Subject: PPR-17-062 Mobile Office on Palmer Park Road

Review comments have been addressed below:

SHEET NO:
DP-01
DATE:
02/14/2018
PAGE NO:
1 OF 1

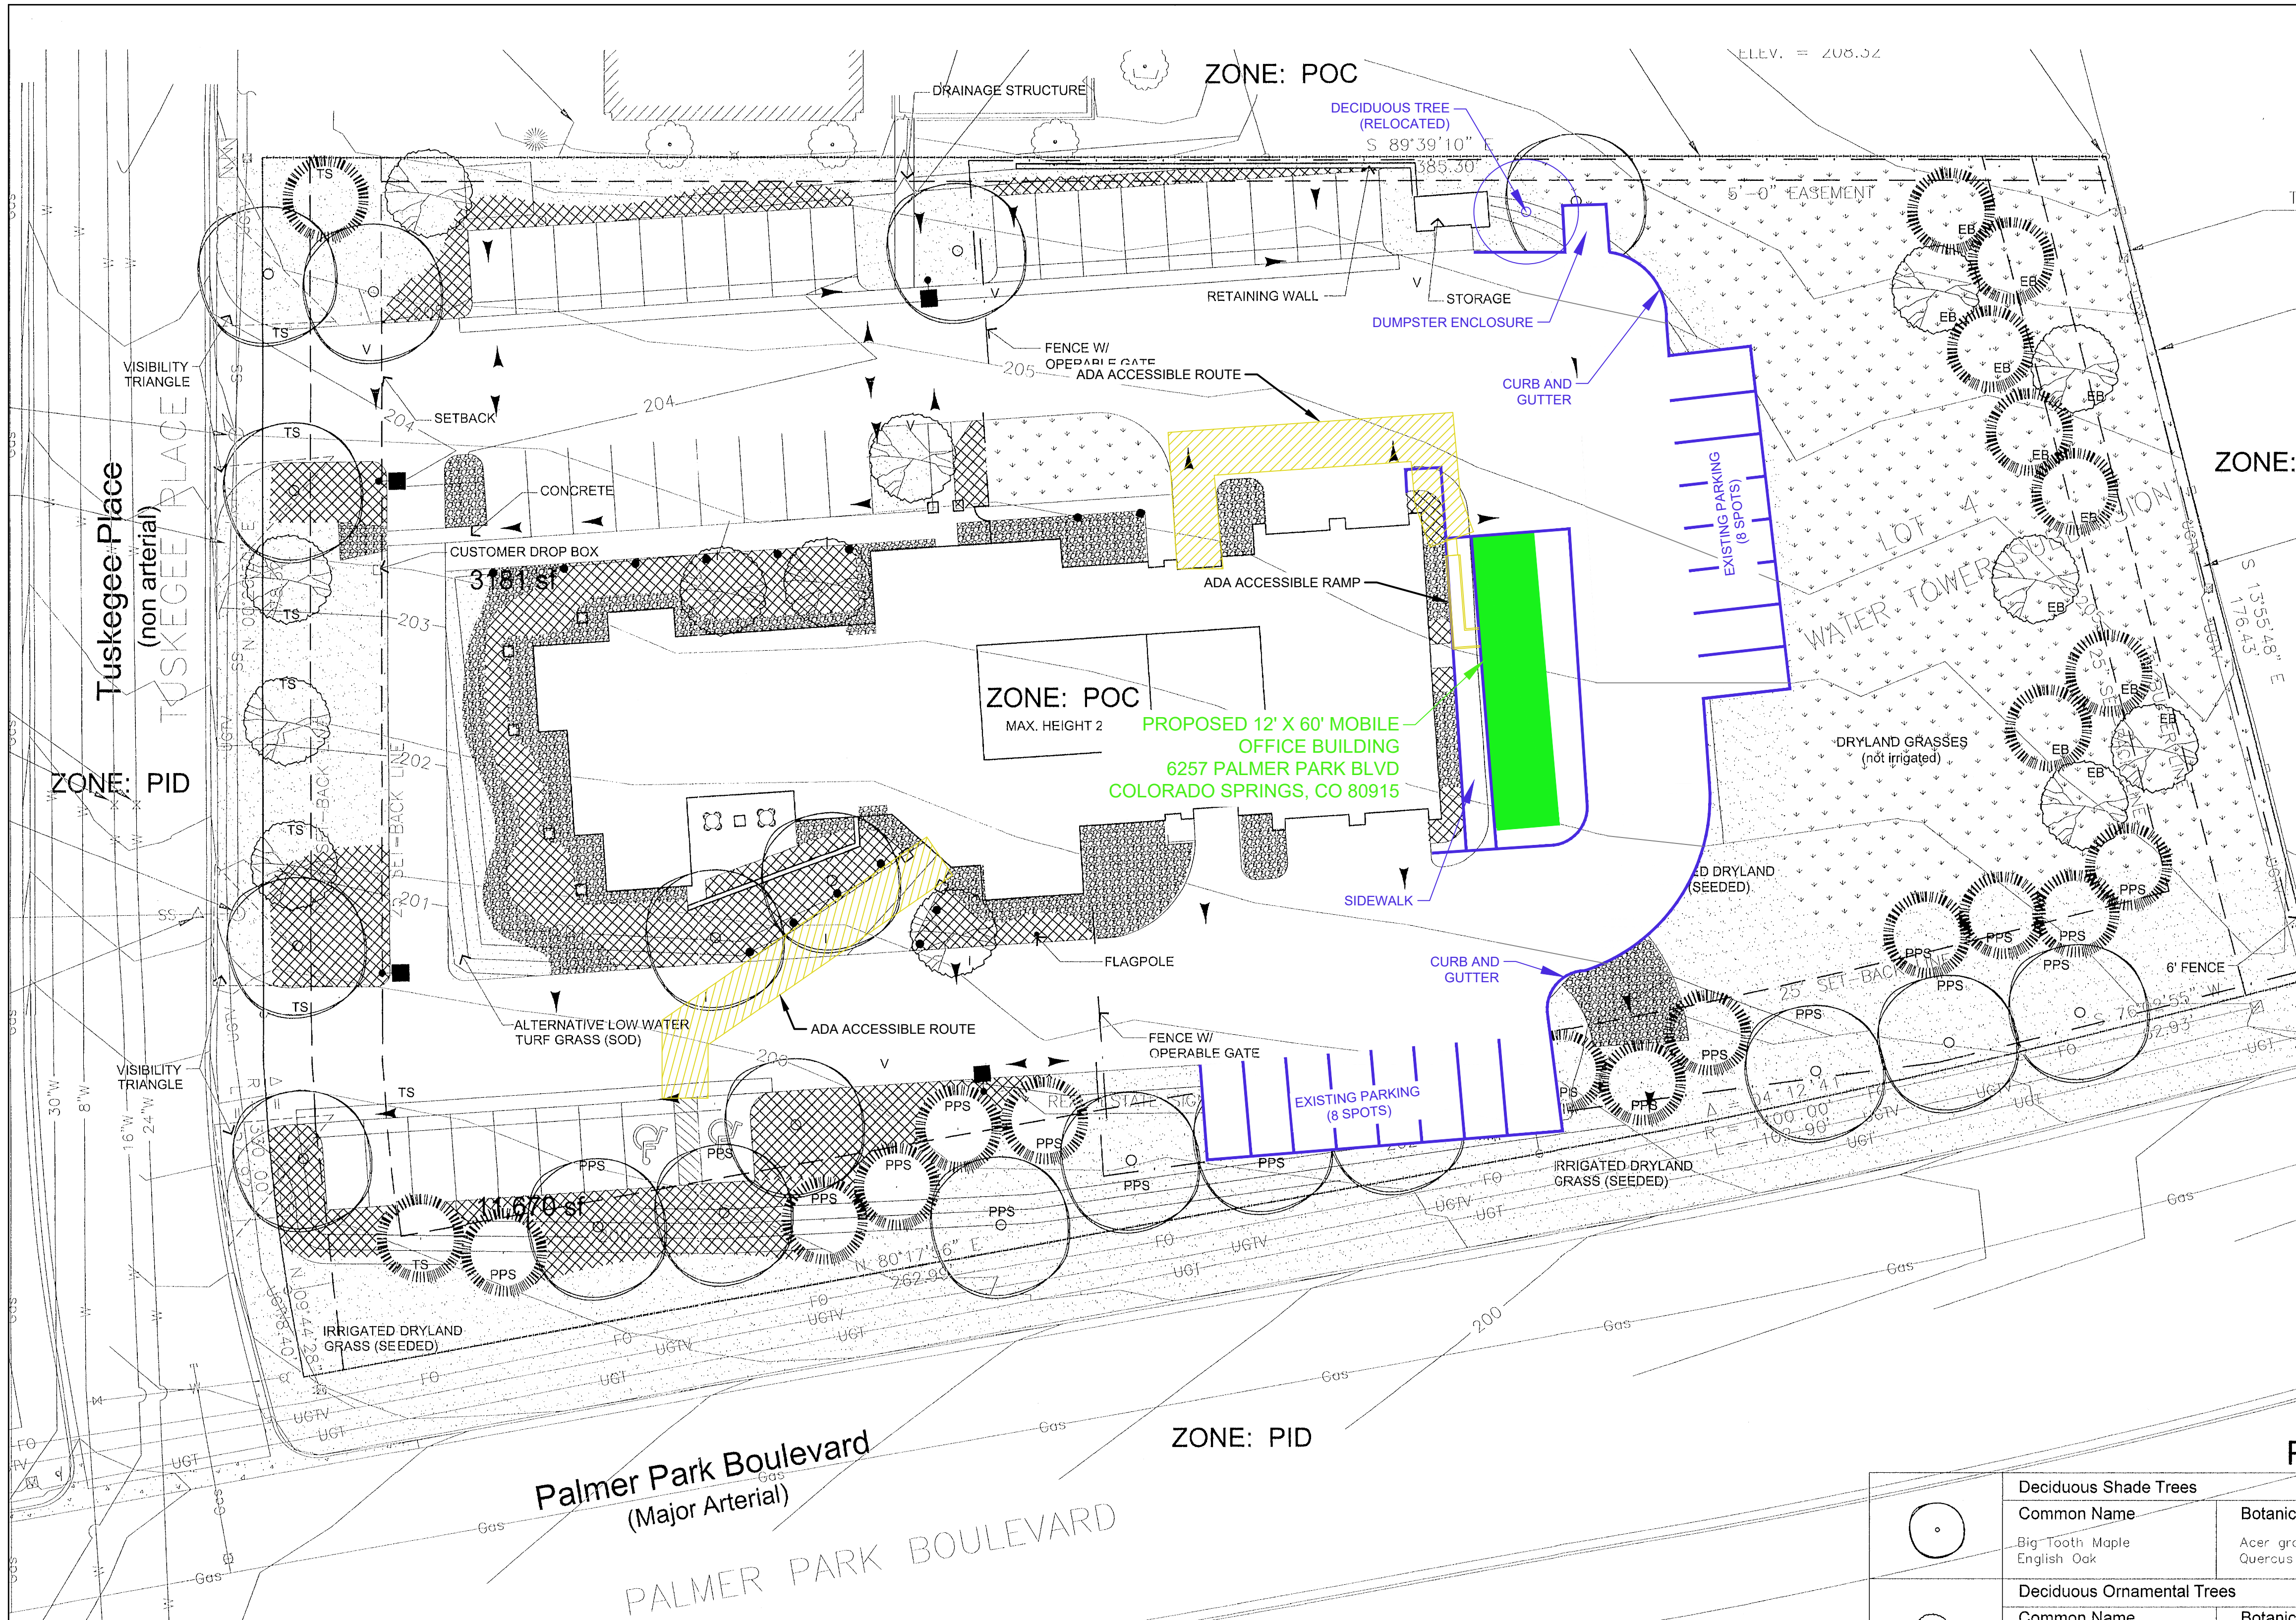
Looks at thought the trailer will not be attached to the existing building therefore, a new address will be assigned to the trailer. Please use 6257 Palmer Park Blvd. No further comments. – [6257 Palmer Park Blvd shall be shown on plans.](#)

MOBILE OFFICES
ADA ACCESSIBILITY PLAN

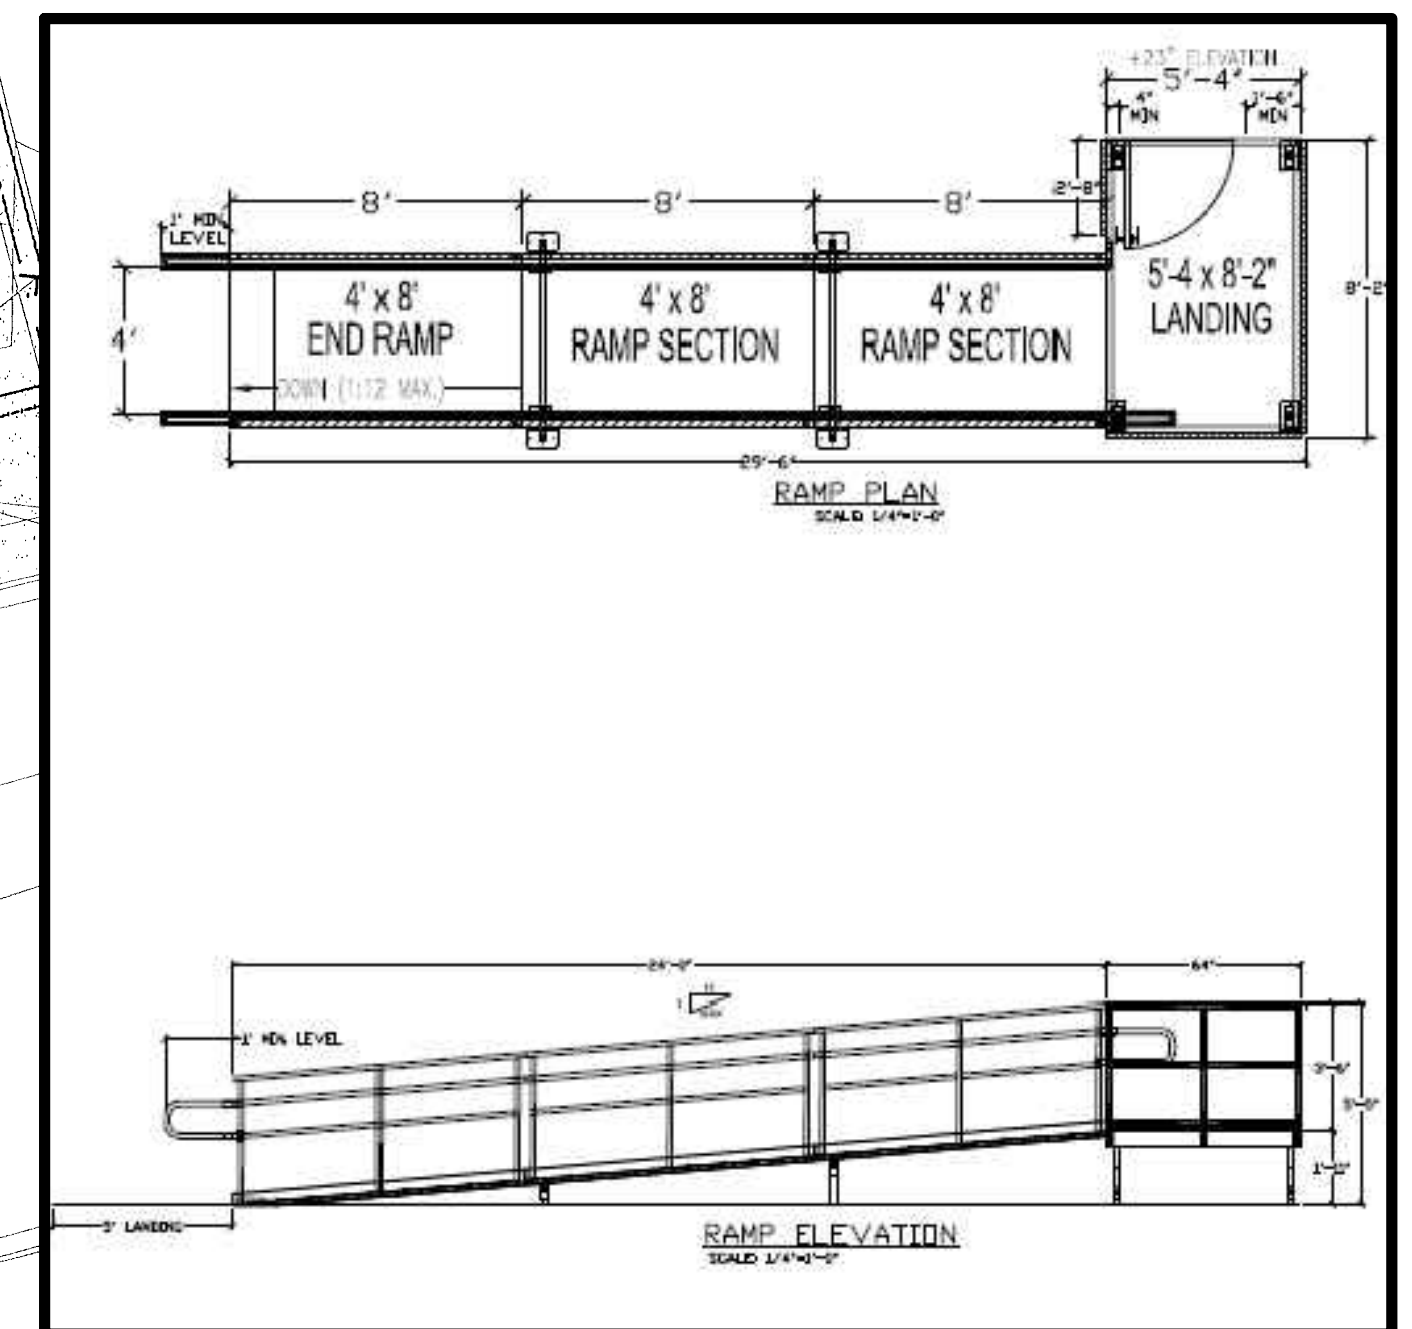
- Applicant is required to apply for a Building Permit with PPRBD – [Building Permit shall be submitted.](#)
- Address addressing issue with enumerations – [Address has been modified on plans, as requested by enumerations.](#)
- See redlines – [All redlines addressed. Drawings resubmitted.](#)
